Project #: 1009886 *Application #:* 13DRB-70745

Project Name: MRGCD MAP # 40

****Your request was approved on 11-21-13 by the DRB with delegation of signature(s) to the following departments - outstanding comments to be addressed****

**PLAT OF
LOTS 1 & 2
LANDS OF ABENICIO GALLEGOS**
BEING A REPLAT OF TRACT 68, 82-A-2, 82-A-1-A & 82-A-1-B
M.R.G.C.D. MAP NO. 40
PROJECTED SECTION 20, T 10 N, R 3 E, NMPM, TOWN OF ALBUQUERQUE GRANT
CITY OF ALBUQUERQUE, BERNALILLO COUNTY, NEW MEXICO
NOVEMBER, 2013

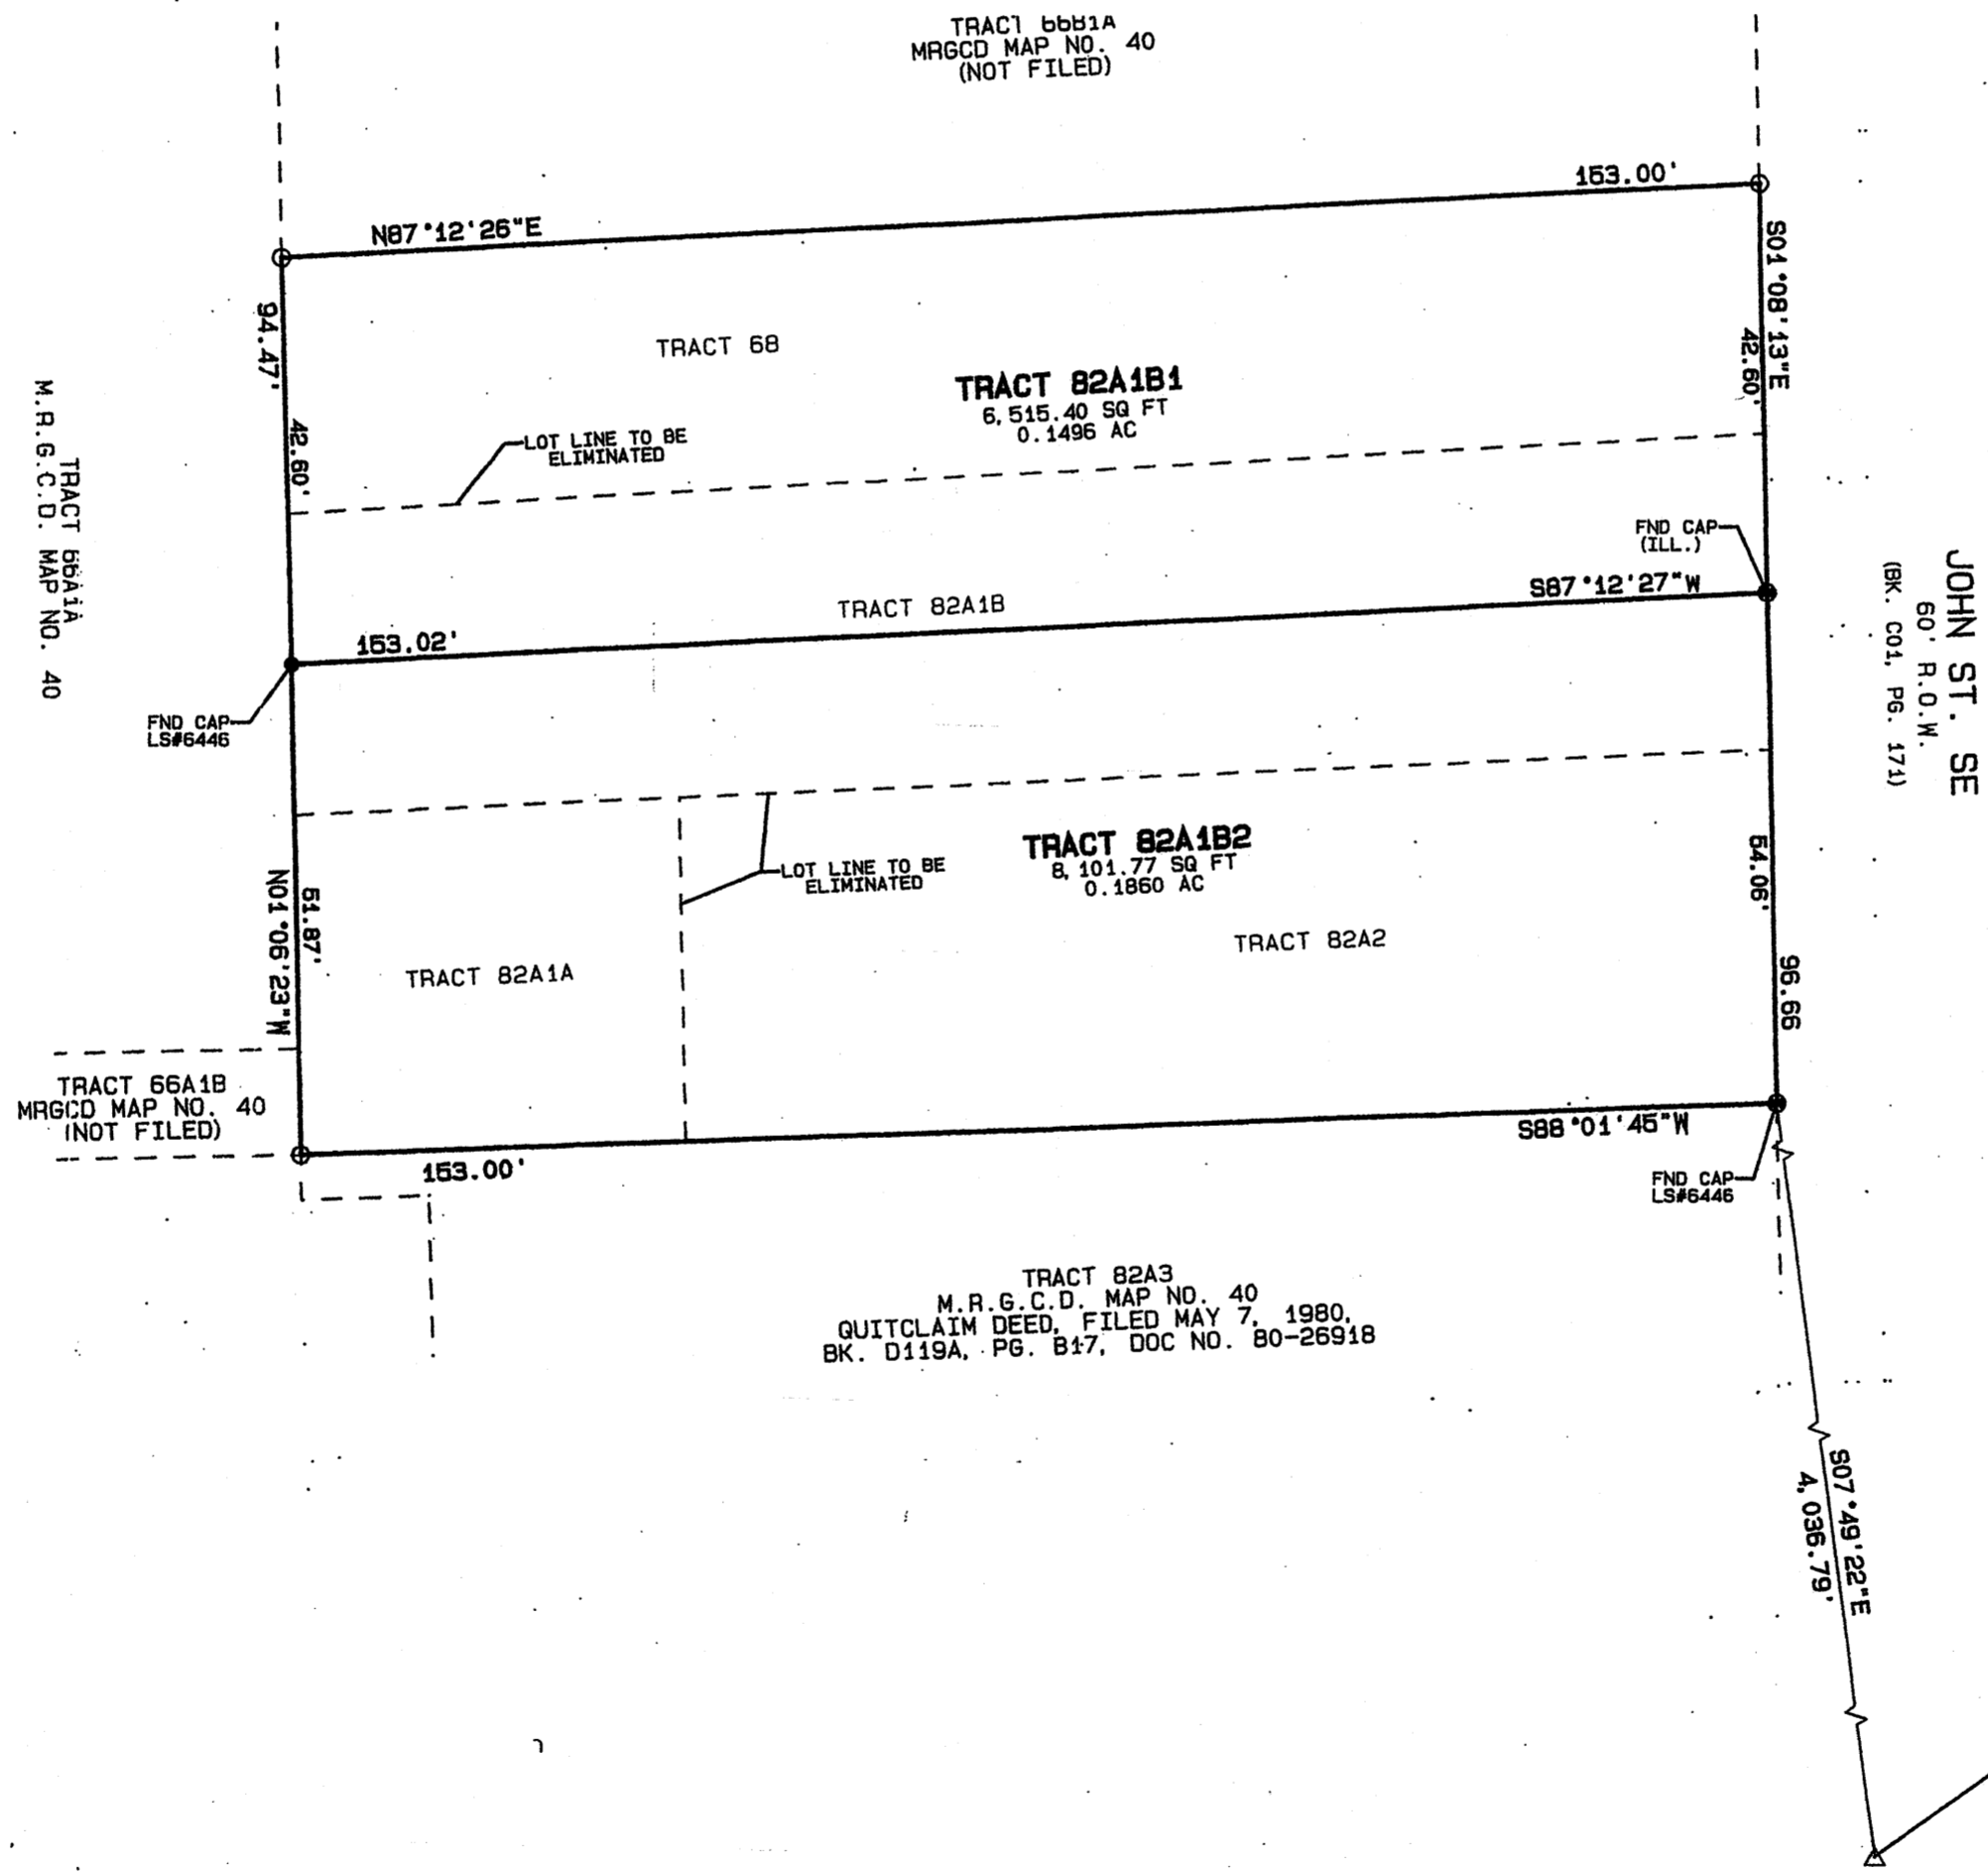
PLANNING (Last to sign): • revise Note 11 8-16-12
• delete Note 12
• verify signatures
